Our Ref: AWE200083-L01: BCP/bcp
Contact: Dr Brett C. Phillips

22nd February 2021

RESPONSES TO FLOODING SUBMISSIONS, ASPECT INDUSTRIAL ESTATE, KEMPS CREEK, NSW

Figure 13 2 yr ARI Velocity Differences - (Stage 1 Conditions – Benchmark Conditions)

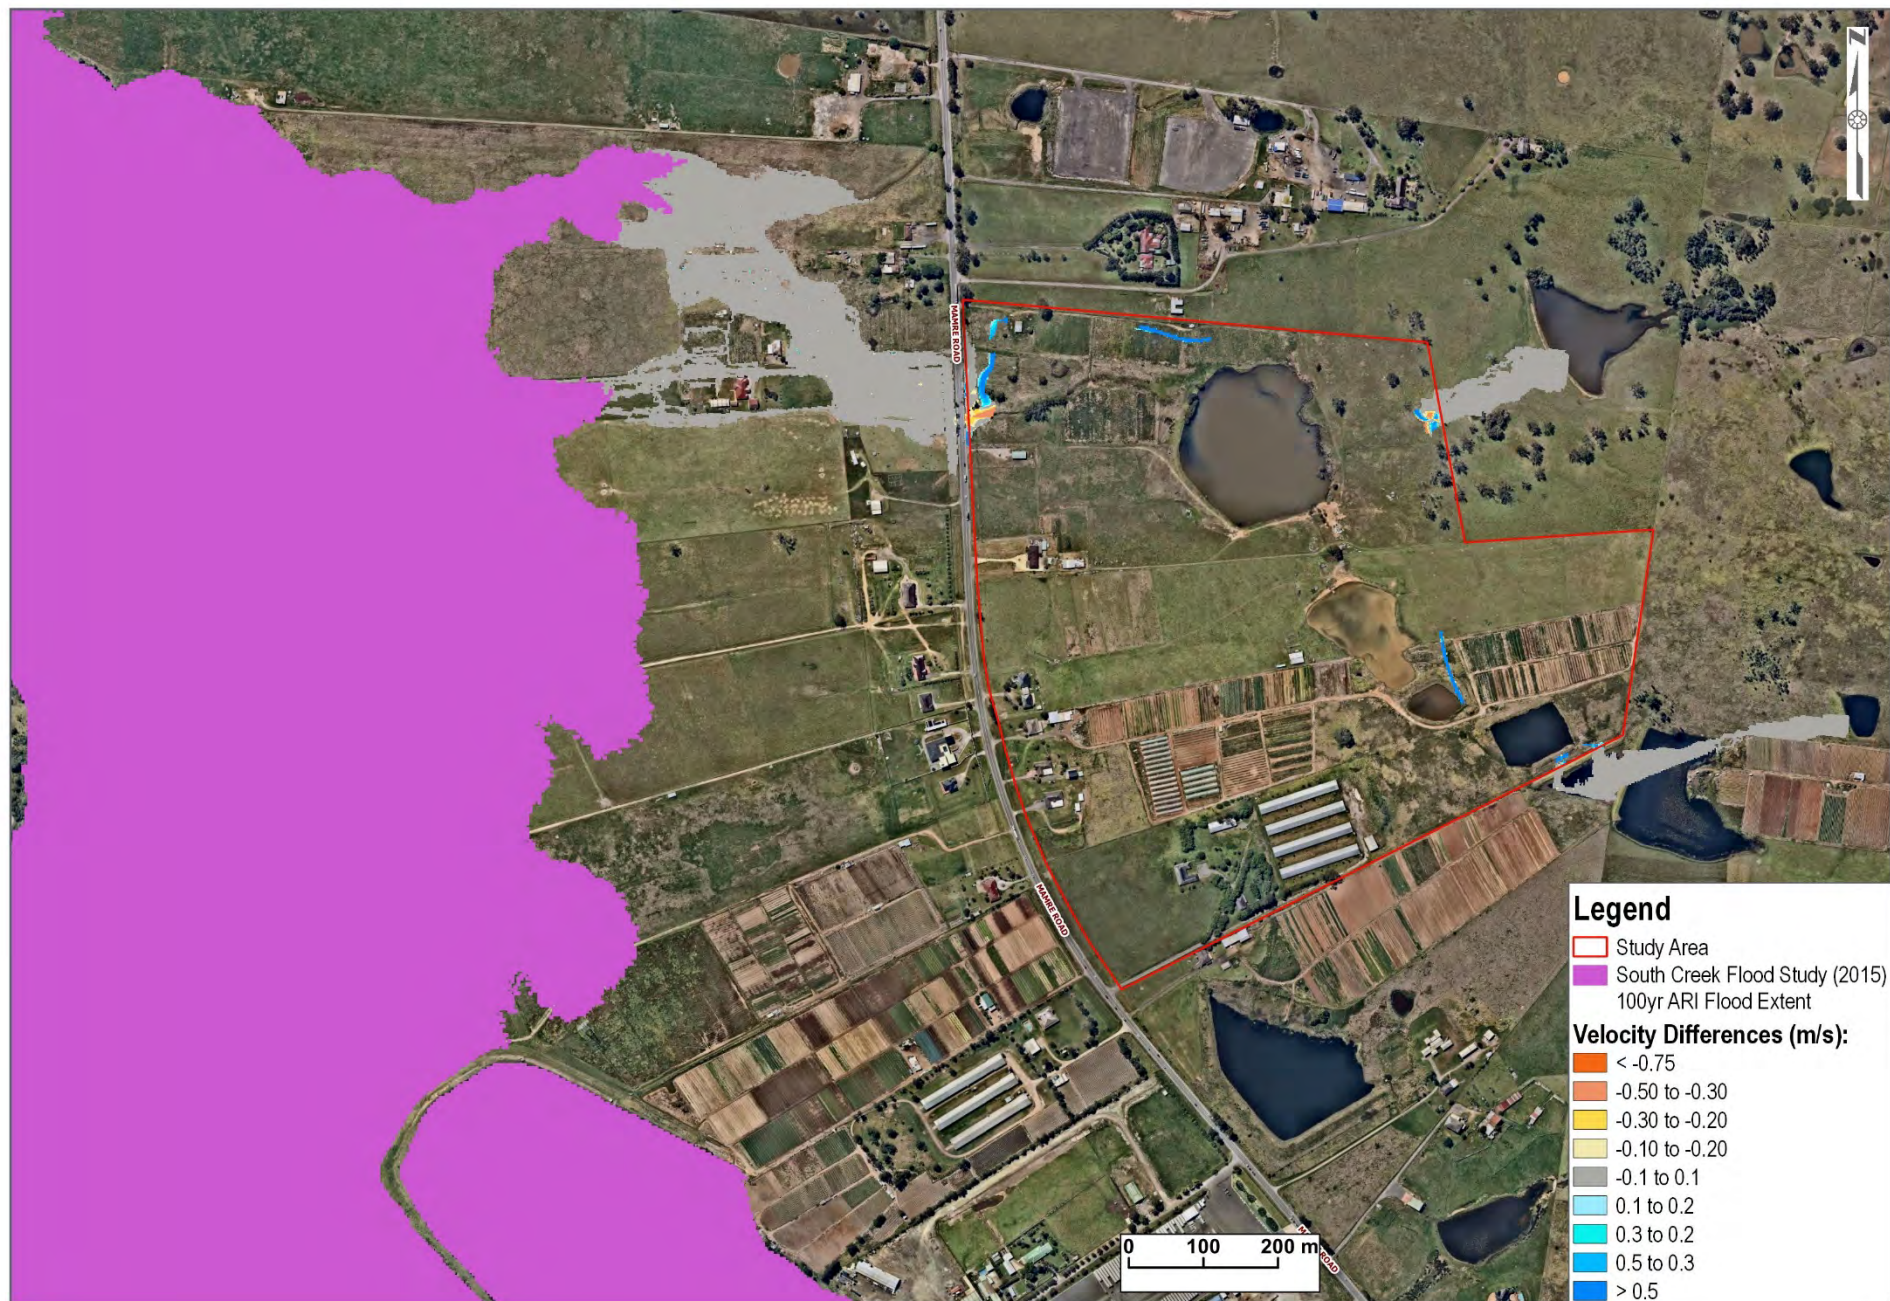
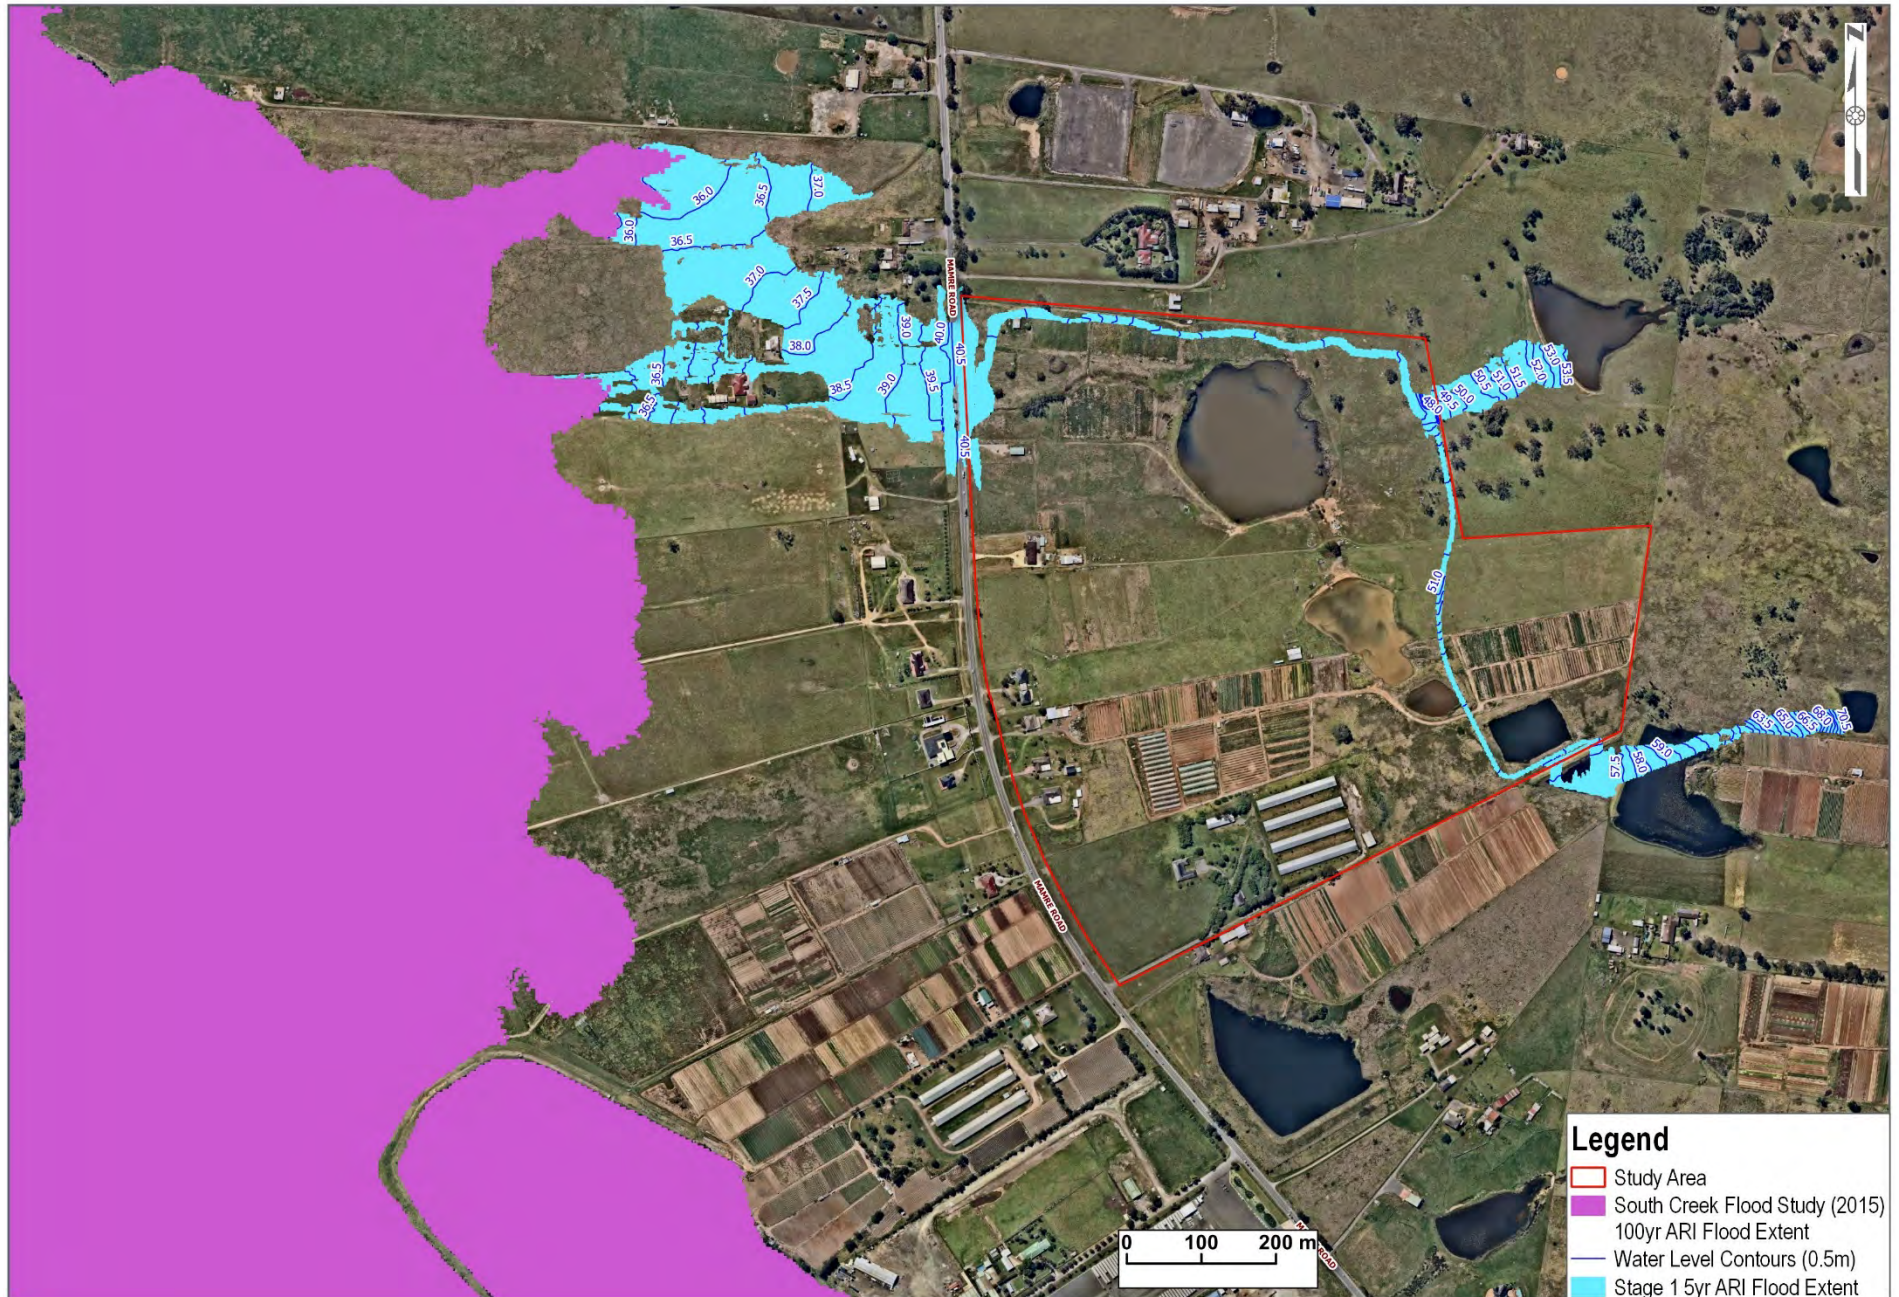
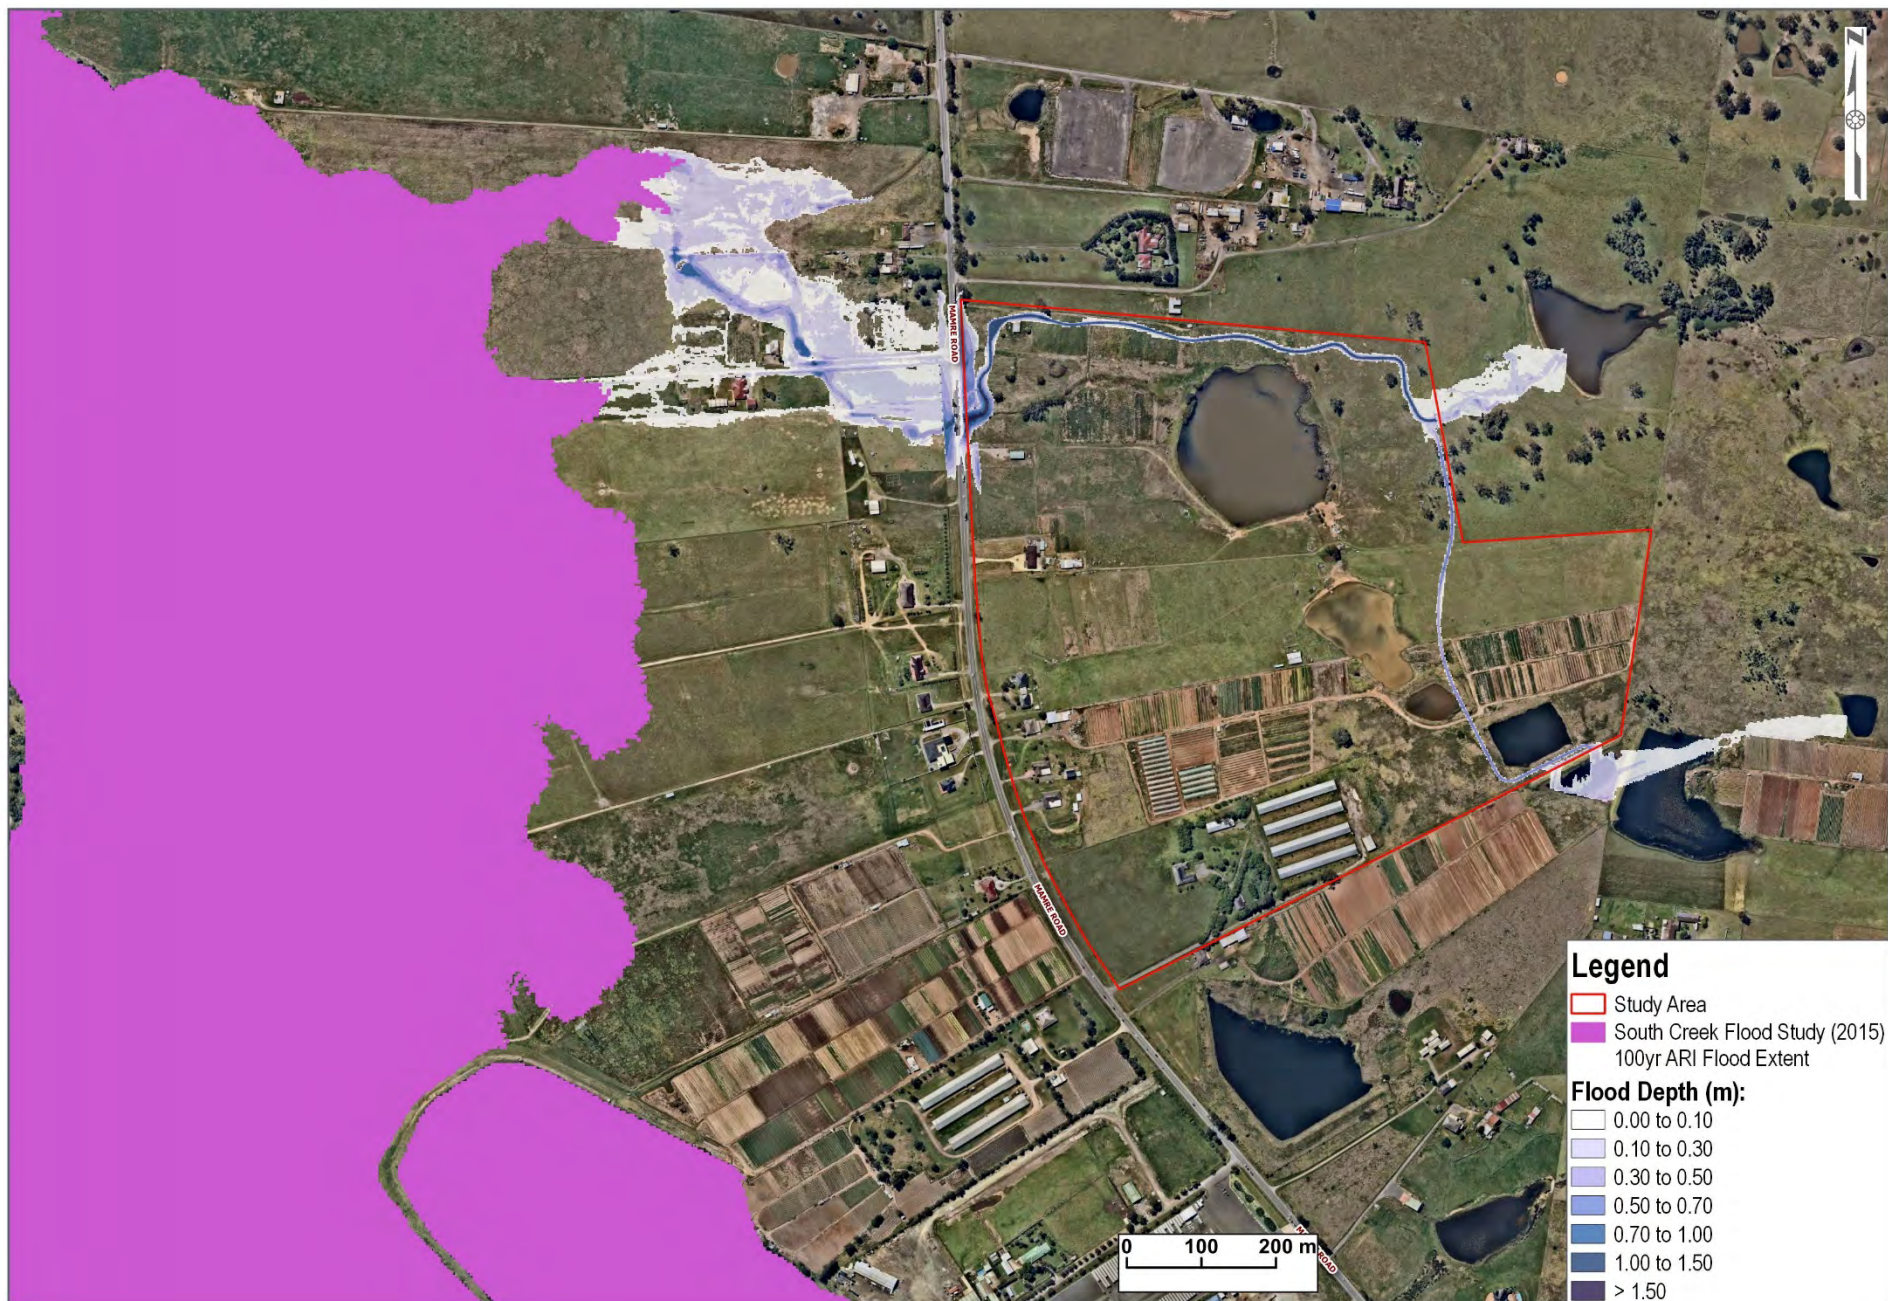
- *The developed scenario maps present local overland flow for Stage 1 which comprises of two industrial lots on the northern part of the site. However, from a flow management perspective, an overland flow study should consider the ultimate developed scenario of the site instead of considering each progressive development independently.*

- *All maps for developed conditions should properly depict the layout of the development, locations of proposed constructed channels and the location of the proposed detention basin.*

The final masterplan has been assessed and the results of the assessment have been incorporated into an updated version of the FIA report.

The updated Figures have been incorporated into an updated version of the FIA report.
